Permit Number: 081397

has permission to Apartment Remodel

AT 20 HILL ST C# 054 C001001

<b>Proposed Use:</b> 2 Family Home - Apartment remodel	<b>Proposed Project Description:</b> Apartment Remodel
---	---

SITE PLAN

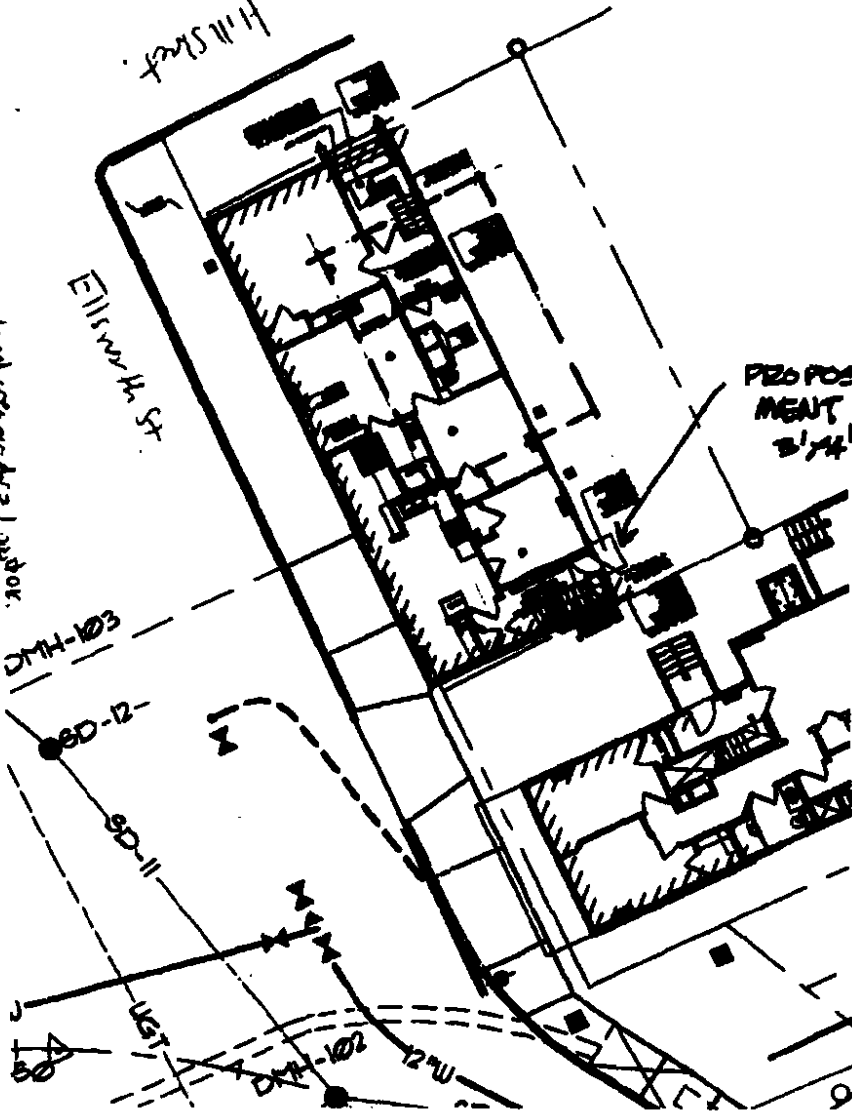
<b>Comments:</b> 11/3/2008-amachado: Left message for Peter Bass. Is replacement platform on the left rear side same size as existing? Does not appear to be.
--

PROPOSED REPAIR  
 MENT PLATFORM  
 3'x4' must be  
 same side  
 as existing
